Our ref: DOC20/347033

**Response following proponent response to Heritage NSW RTS letter for Dendrobium Coal Mine Extension Project (SSD-8194)**

Department of Premier and Cabinet  
**As Delegate of the Heritage Council of NSW**  
7 July 2020

### FIGURE 7

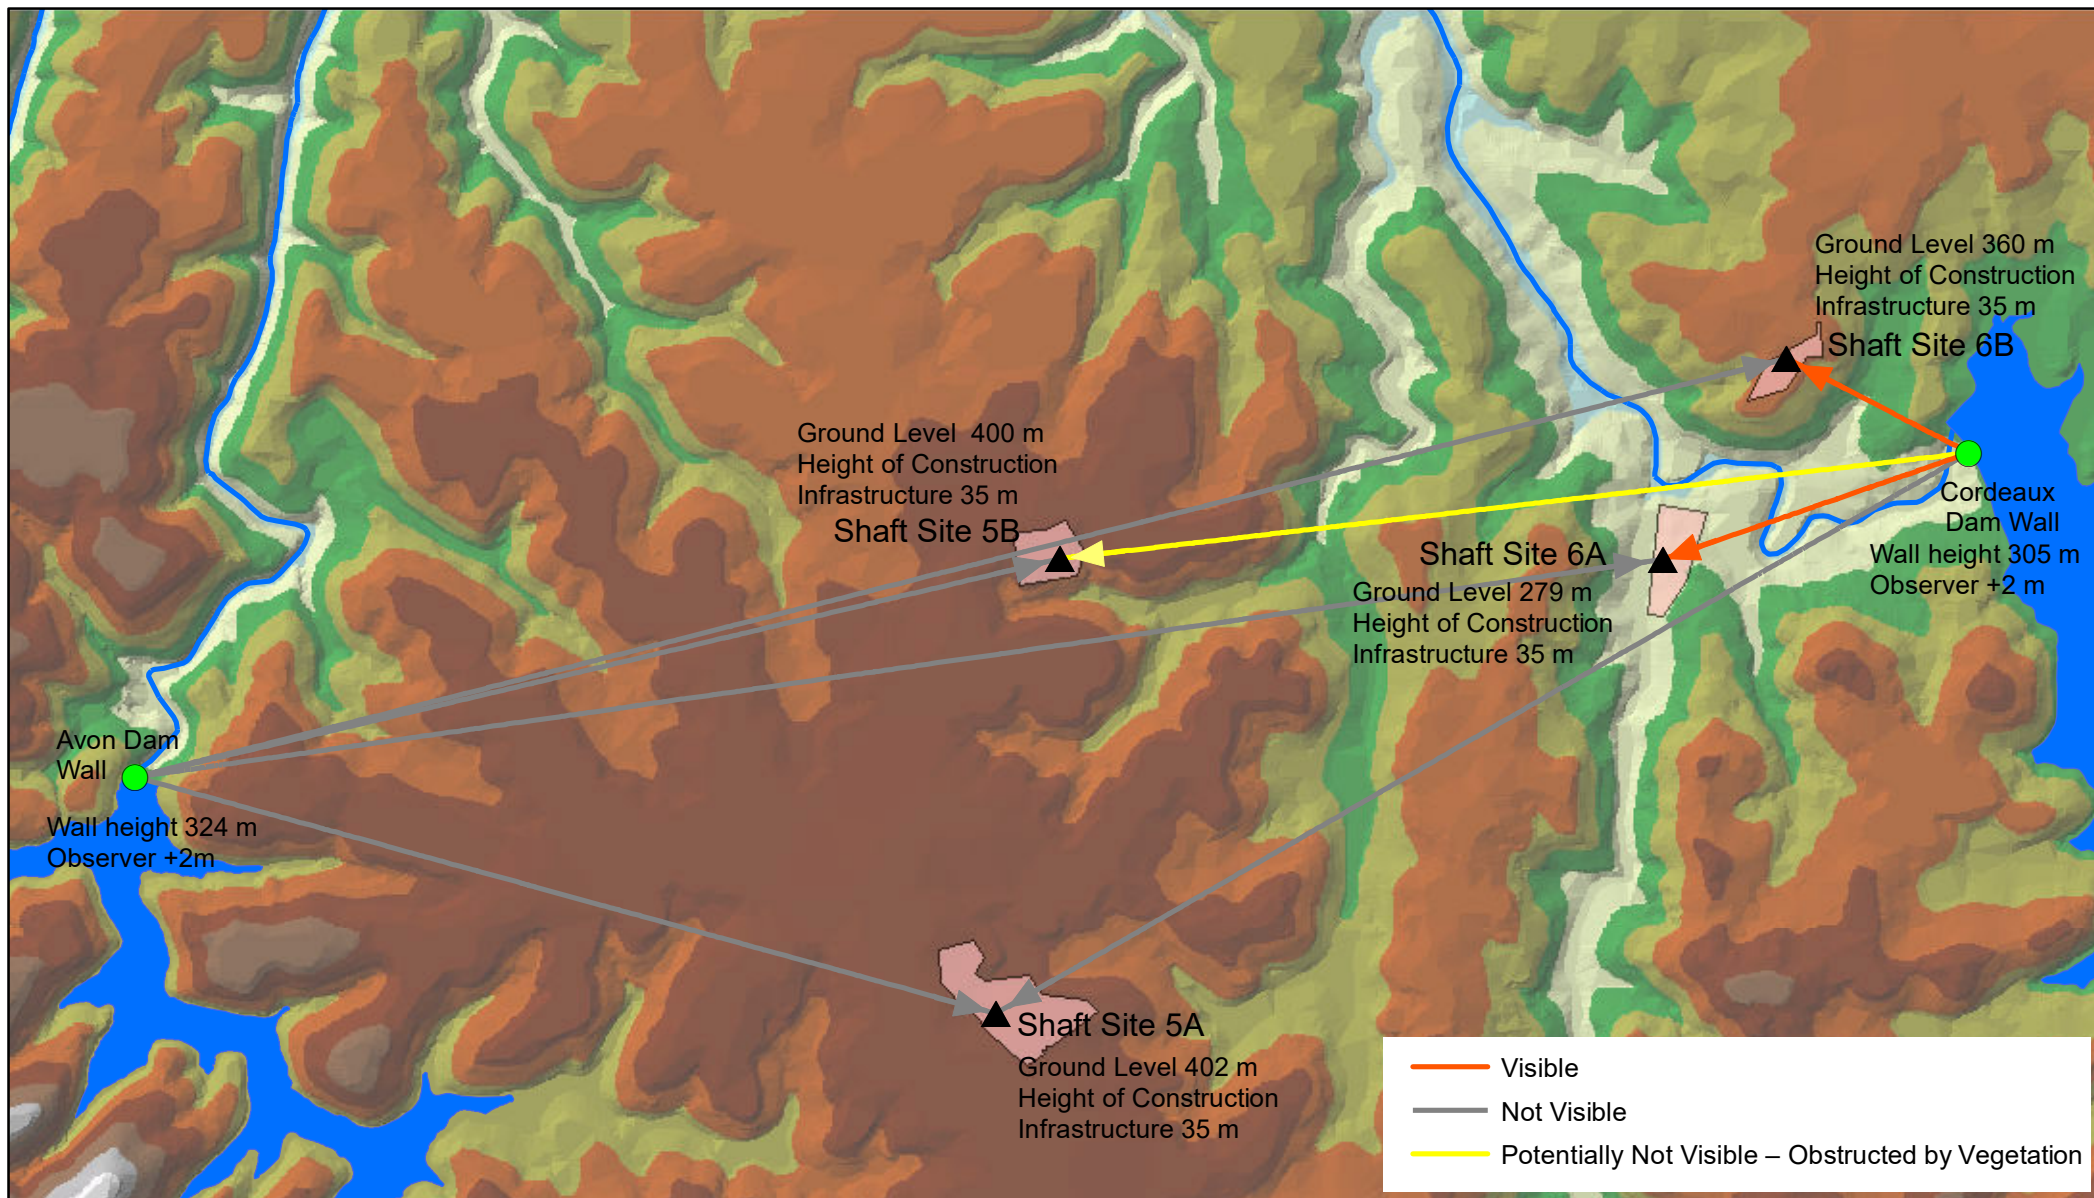
Letter 2 clarifies the location of the proposed ventilation shafts sites (6A and 6B) in relation to the Cordeaux Dam SHR curtilage area and the existing infrastructure. The shaft sites are proposed outside of the SHR curtilage area. Two views from the Cordeaux Dam wall are provided showing existing infrastructure (Cordeaux Pit Top and ETL Towers). The letter notes that the shaft sites are proposed further than the ETL towers and would be lower in height, and that therefore these sites may be obstructed due the topography and vegetation. Even though the shaft sites' height and distance from the Cordeaux dam wall might reduce the visual impacts, a photomontage of these sites was not provided and therefore the full visual impact is not clear.

**FIGURE 8**

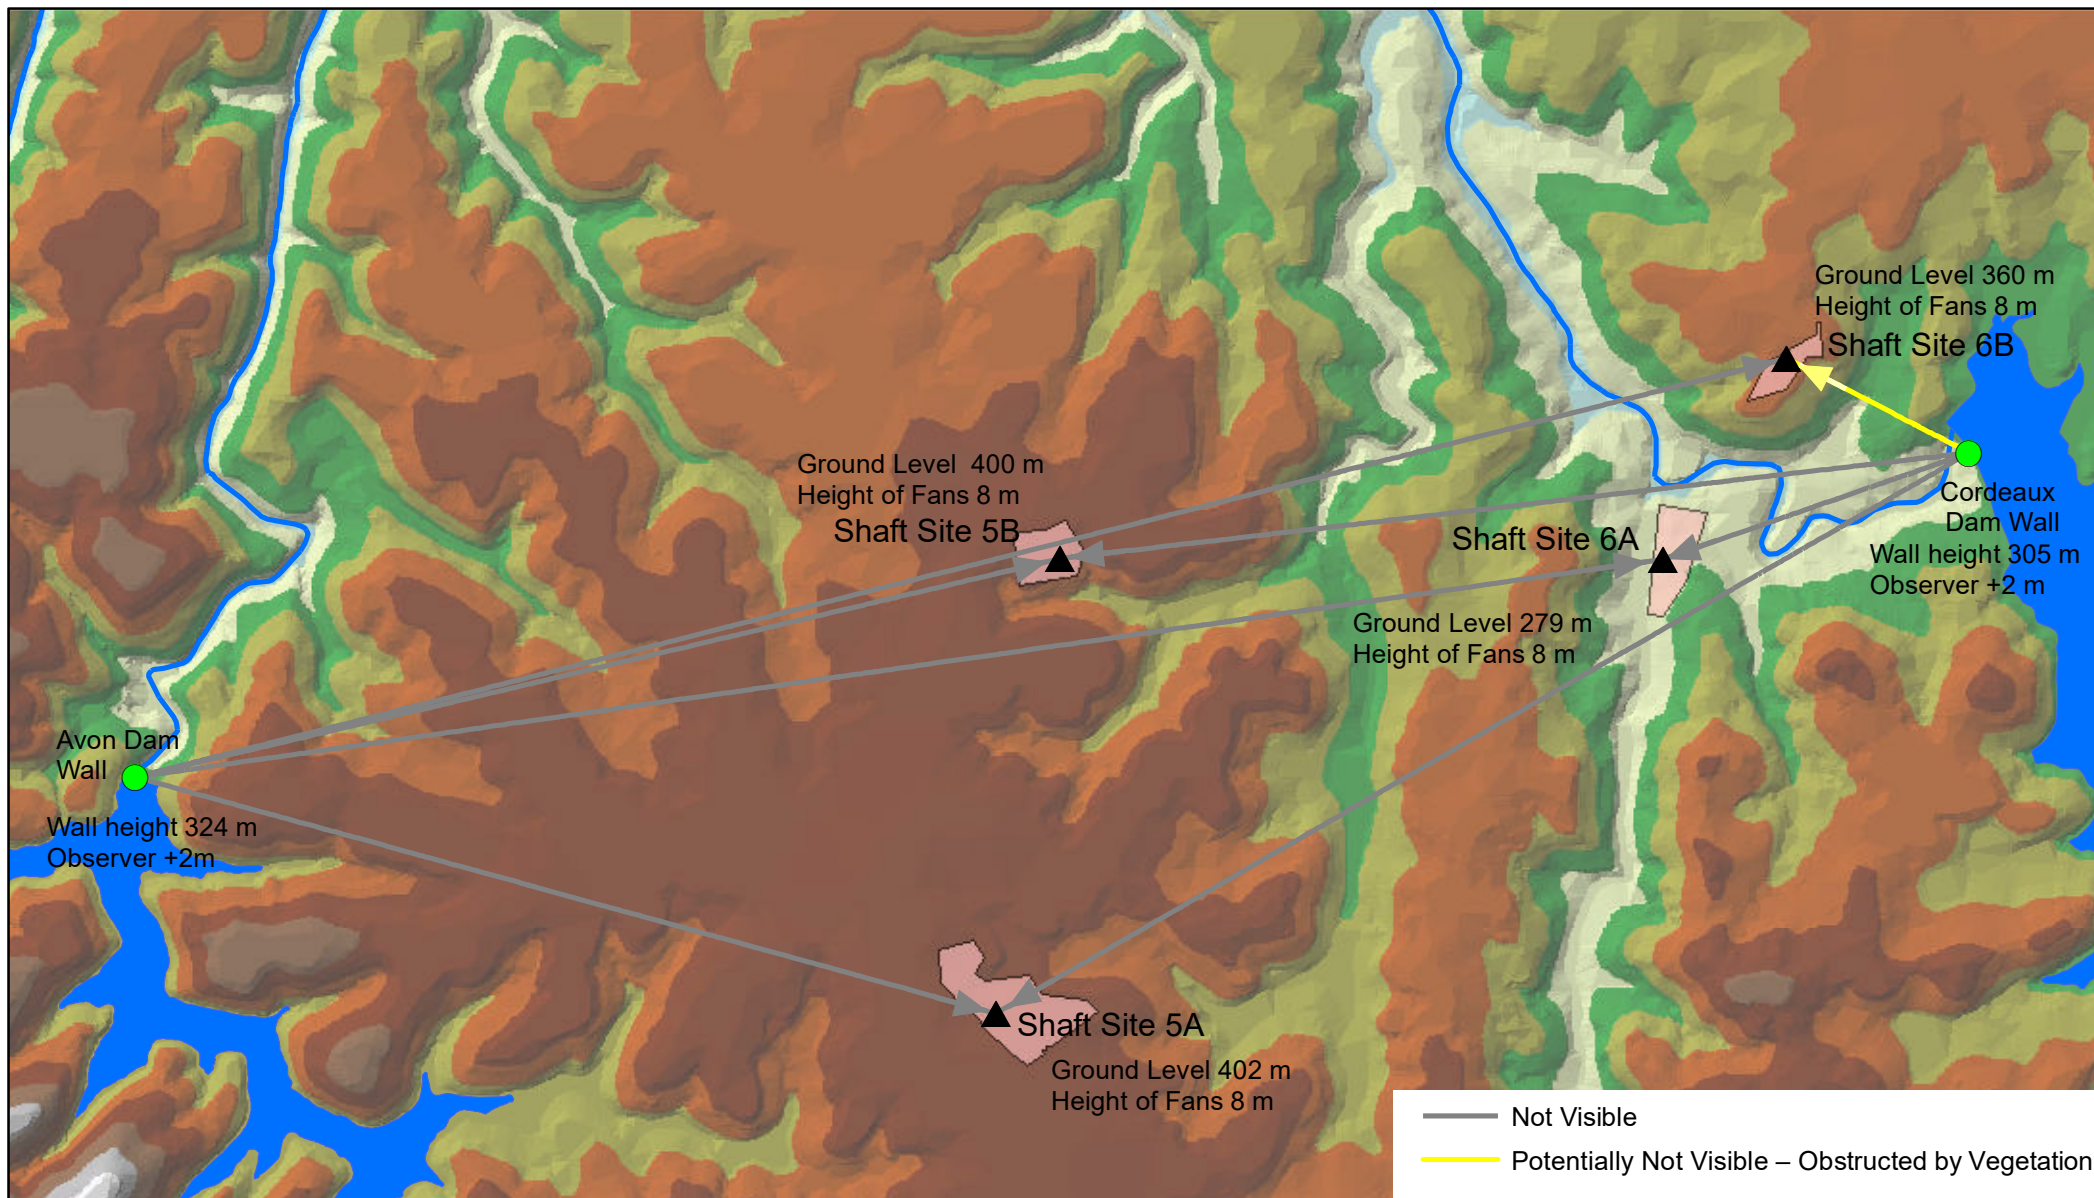
Letter 1 clarifies that the height of ventilation shaft infrastructure during construction stage would be significantly higher (35m high) than the height of infrastructure during operation phase (fans 8m high; flares 15m high).
